From: Christina Wollman
Sent: Tuesday, September 15, 2015 11:05 AM
To: Lindsey Ozbolt
Subject: RE: VA-15-00001 Heric - Notice of Application

[VA-15-00001 Heric](#)

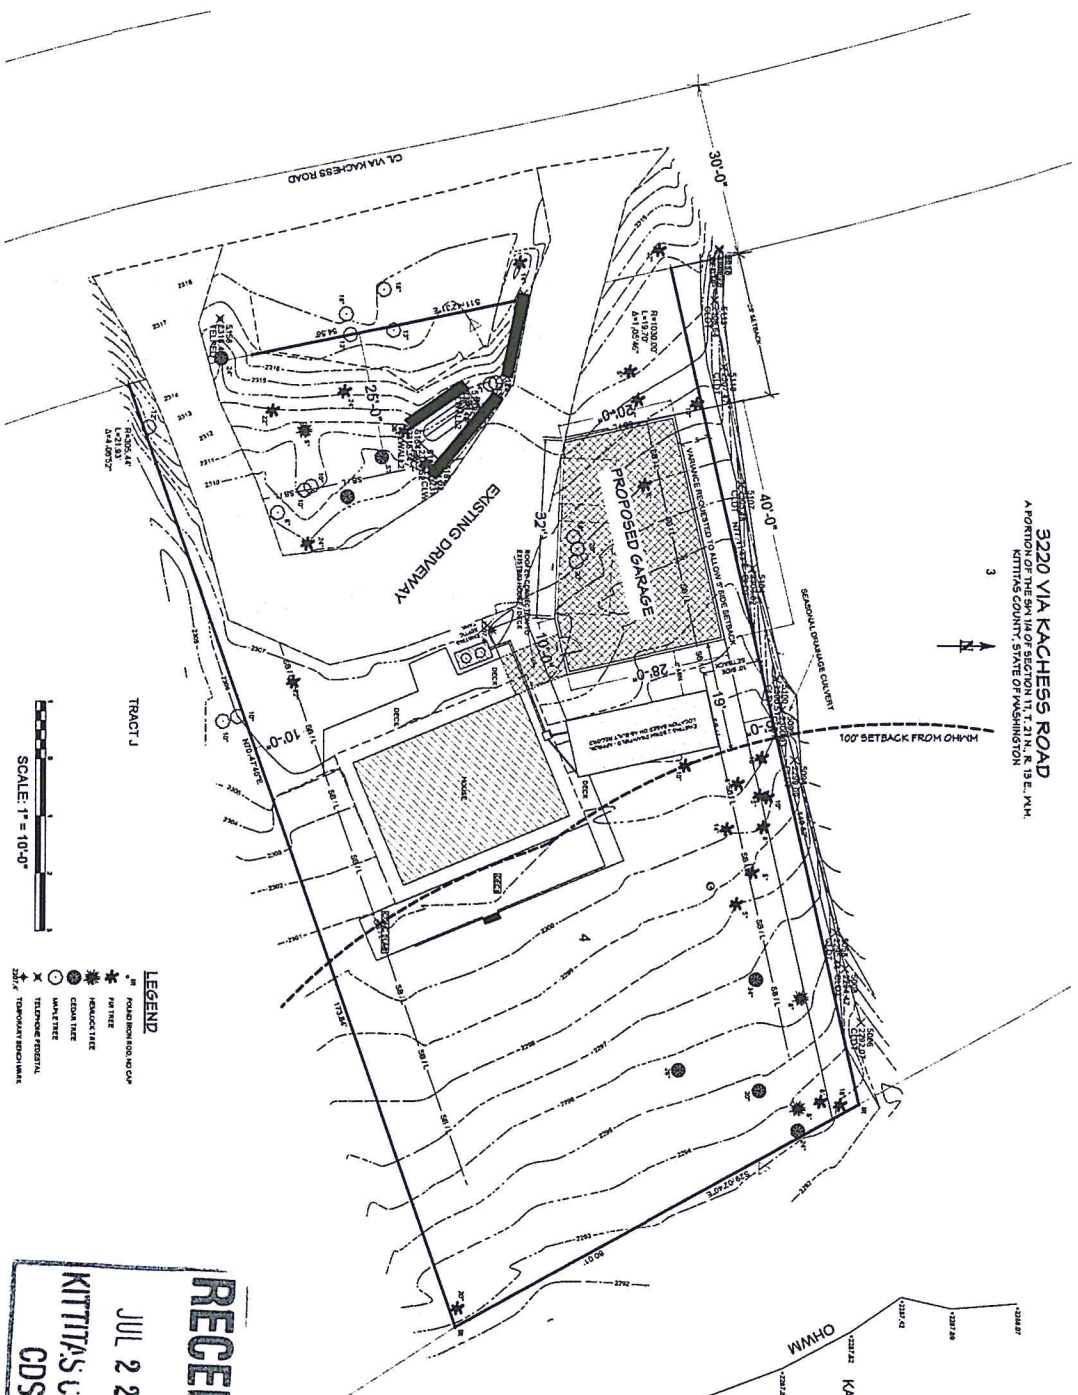
- There are no issues concerning the placement of the structure in relation to the county road.
- There is no parking allowed on the shoulder of Via Kachess Road in the area of this parcel.
- Sufficient on-site parking shall be reserved for the property.
